AW/331/18/DOC

The current application relates to two conditions applied to AW/187/18/PL and relates to the provision of:

WINDOW SECTION.

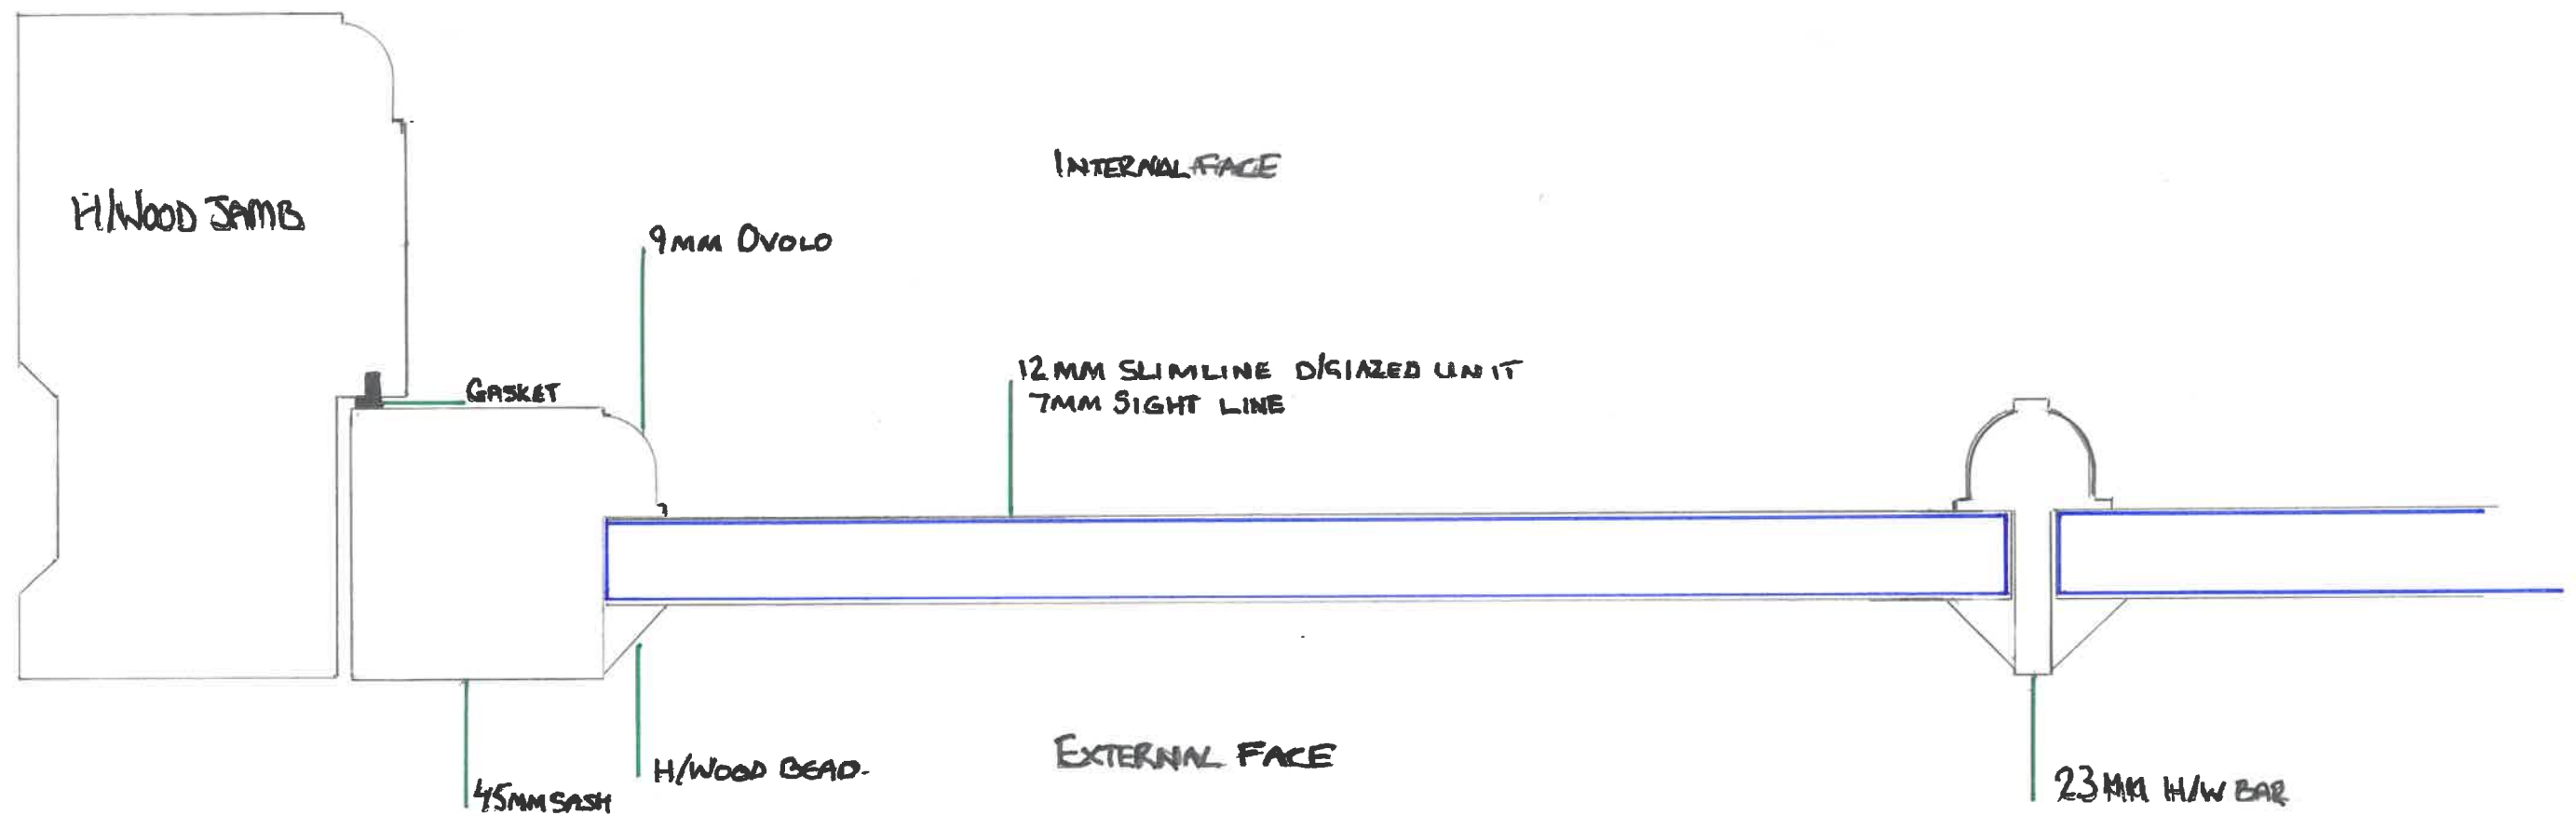
Therefore, I will require alternative sample of the slate as well as scaled drawings/sections of the proposed windows.

With regard to the new joinery, I note that a list of materials has been provided, along with two photographs of similar doors/windows on the existing property. Reference to the use of hardwood is acceptable, as is the colour (white). However, as only two photographs have been provided, as opposed to some form of scaled drawing indicating measurements, it is not clear if the proposed windows will be a true like-for-like copy, or merely similar in appearance. It is considered that some greater certainty would be required.
